Our Ref: 71887/GMP/20070108_Response to Fraser Drive Residential Subdivision – Briefing Memo.doc

08/01/2008

RE: RESPONSE TO FRASER DRIVE RESIDENTIAL SUBDIVISION – BRIEFING MEMO

Council Comments Item 73

Fraser Drive Streetscape / Boundary Fence - Typical Elevation

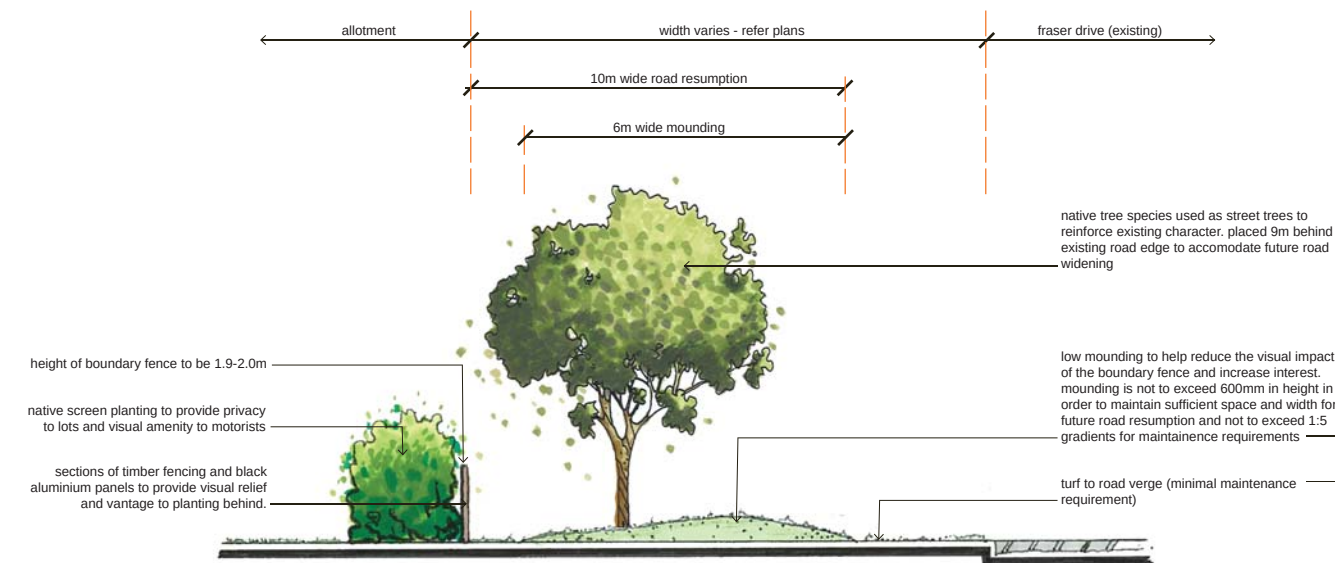
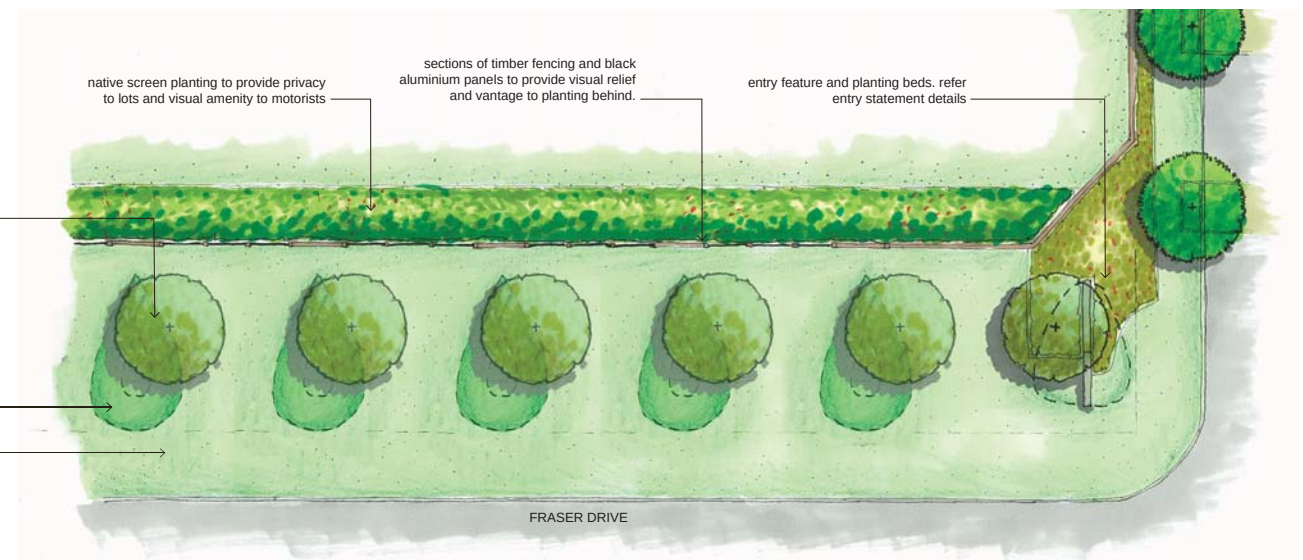
The applicant is requested to provide a cross section of the Fraser Drive frontage depicting the levels of dwellings, fence, mounding I landscaping, proposed height of fill and the ground level in the adjoining road reserve.

The Visual Impact Assessment does not make any assessment of the proposed acoustic barrier that will be constructed between Fraser Drive and the eastern boundary of the proposed subdivision. An assessment of this structure should be undertaken.

It is difficult at this stage to provide sections without further civil, structural and acoustic information not yet developed due to the status of the project. There is a large amount of detailed (construction) information required in order to illustrate how sections would look based on proposed 'cut and fill' levels and building pad heights.

Required acoustic information which details appropriate setbacks for homes from the noise wall and how high those dwellings can be to still be acoustically appropriate for residential use is not yet available.

This information is not yet available to correctly show how the section would look, however typically, a landscape treatment would be proposed to soften the visual impact of the noise wall from inside the lot. Otherwise, the proposed noise wall concept details and character images on sheet 71887_D_CP_06 (01) details the noise wall (fence) treatment, the mounding and indicative landscape treatment.

Please note that the assessment of the acoustic barrier has been addressed within the Landscape Concept Plan Report on sheet 71887_D_CP_06 (01).

The assessment and proposed design solution complies with 'Cardno – Proposed Development Fraser Drive - South Tweed 'Acoustic Assessment (20 December 2006- Job No. 7214/29)'.
'

Further to this, the proposal was developed under the guideline document '*RTA - Noise Wall Design Guideline - Design Guidelines to Improve the appearance of noise walls in NSW*'.

Although not directly stated in the visual assessment report, the proposed vegetation along the acoustic barrier would provide (in addition to the existing vegetation) and increase the visual absorption capacity and therefore minimizing the acoustic barriers impact upon the development and the surrounding streetscape.
